Our Case Number: ABP-317810-23

Re: Open Cycle Gas turbine power plant (350MW) and associated infrastructure
Located on land to the north of Tynagh Power Station, Derryfrench, Tynagh, Loughrea, Co. Galway.

Re: Proposed strategic infrastructure development [ABP-317810-23] by EP Energy Development Ltd. Park North of Tynagh power station, Derryfrench, Tynagh, Loughrea, Co. Galway

See attachment 1 for further clarification required on the COMAH Land Use Planning Assessment for Tynagh OCGT North

CLIENT: EPED
SITE: TYNAGH NORTH
PROJECT: TYNAGH NORTH
TITLE: PROPOSED FUEL STORAGE, TREATMENT & UNLOADING AREA PLAN

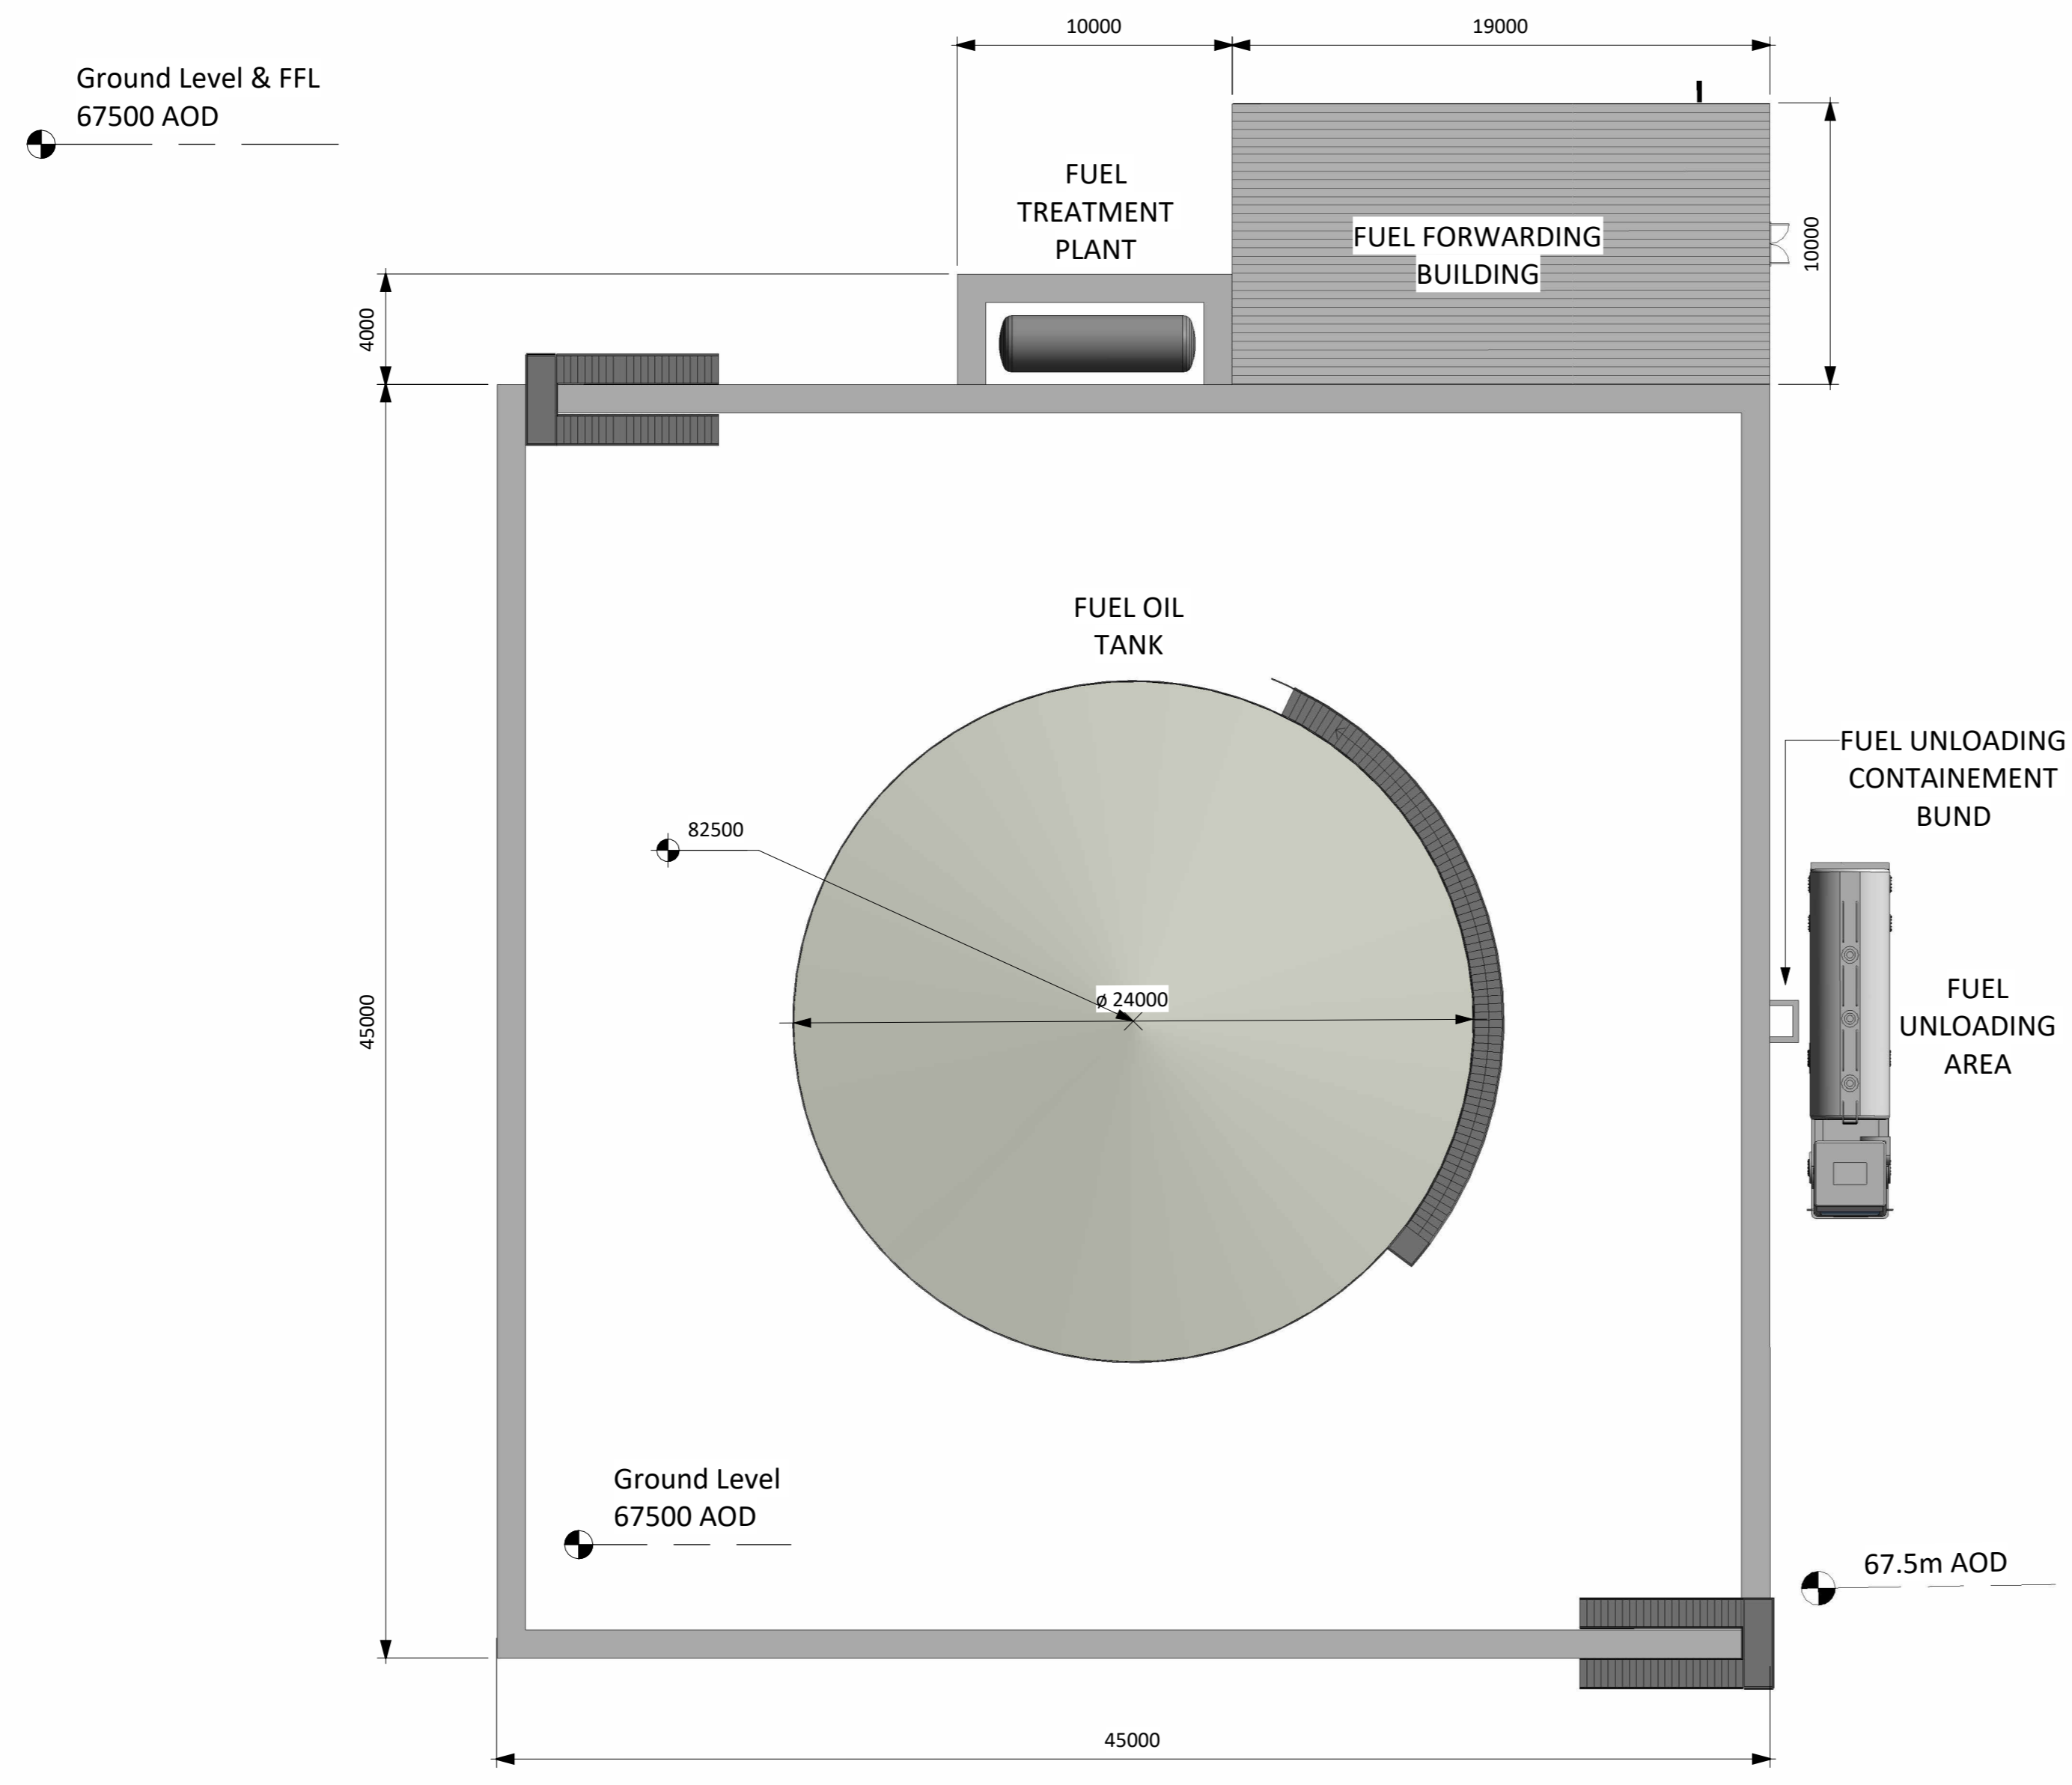
1. The report should include a drawing showing the site boundaries and the location/routes of all major hazards for all three COMAH installations – the current Tynagh Energy site, along with the Tynagh South and North sites. The drawing should show over ground and underground gas pipelines, AGIs, fuel storage bunds, CCGT and OCGT gas turbine enclosure locations, power station turbine hall, hydrogen operations etc. The report does not make clear the location of the Tynagh North OCGT turbine enclosures (only the AGI, fuel bund and underground gas pipelines are shown).

CLIENT: EPED
SITE: TYNAGH NORTH
PROJECT: TYNAGH NORTH
TITLE: OCGT PLAN

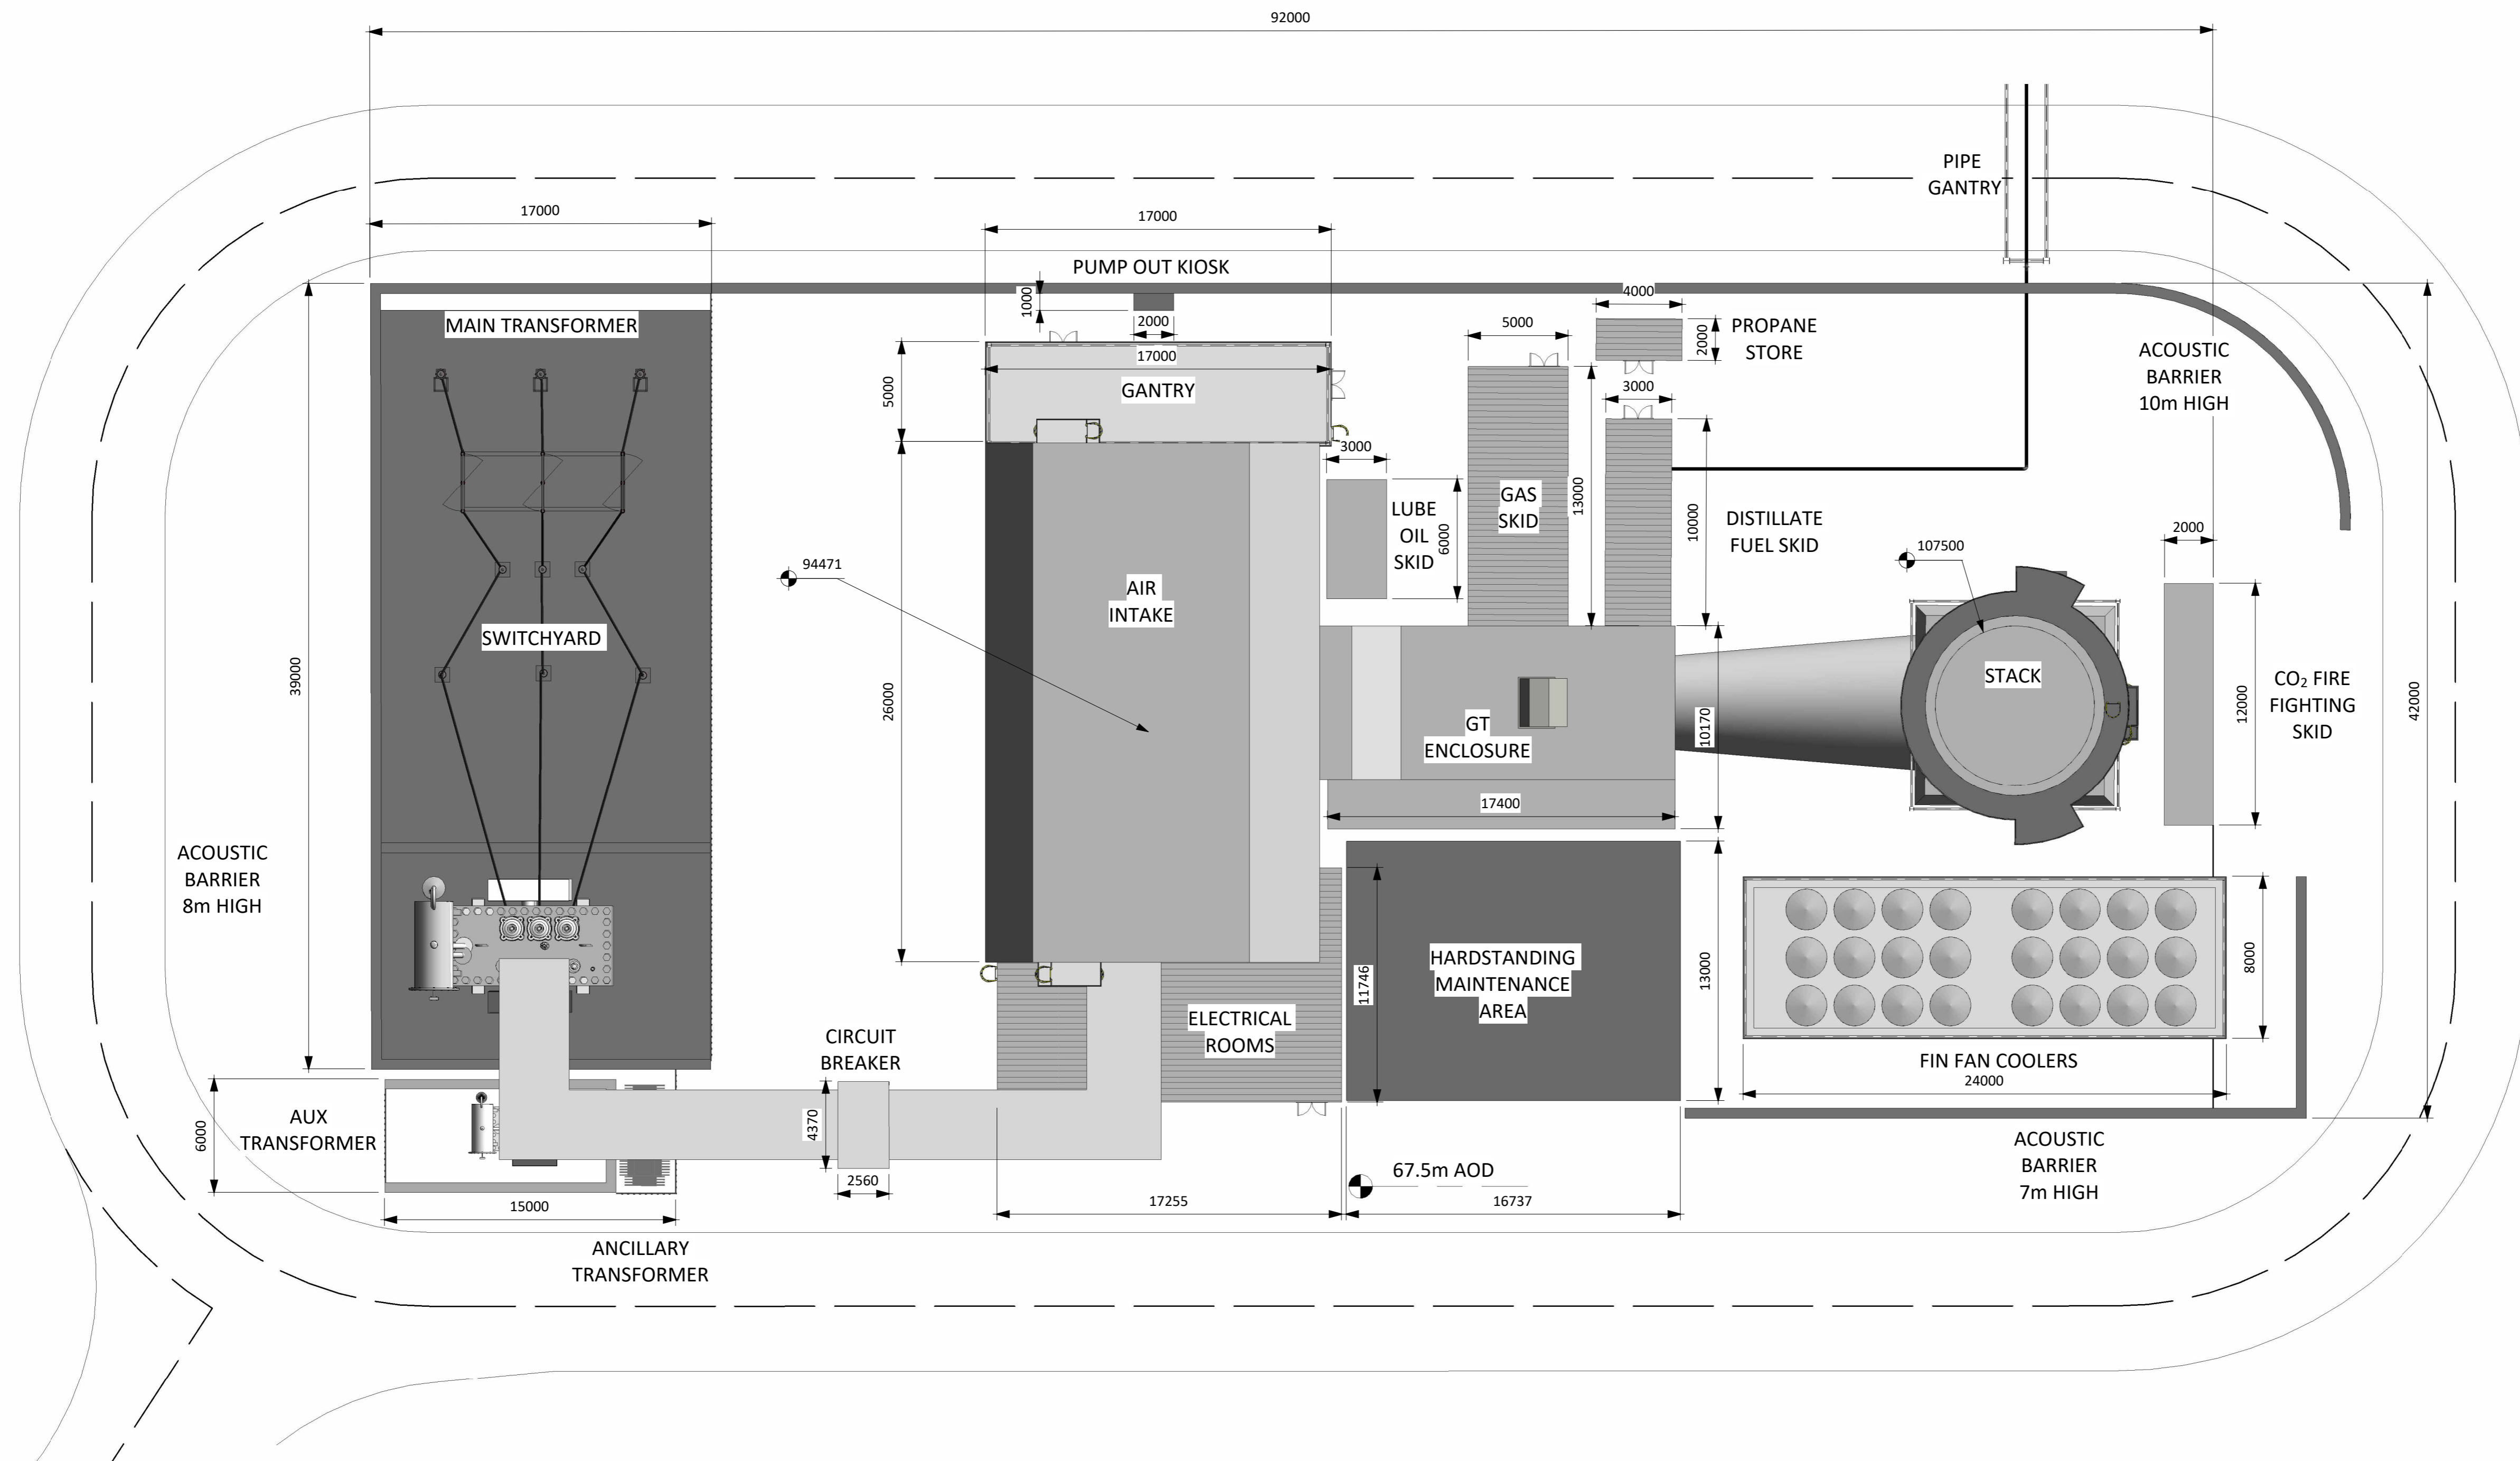
3. Clarification is required on the inventory of dangerous substances to be stored/used on the proposed site.
4. Section 5.1 – the report does not seem to consider the risks associated with a VCE in a gas turbine enclosure for the OCGT. This should be justified or included in the assessment.

Energy along with the Tynagh South OCGT site. It is expected the most significant events would be a major release/rupture at the AGI leading to a fireball and a VCE in a turbine enclosure or turbine hall.
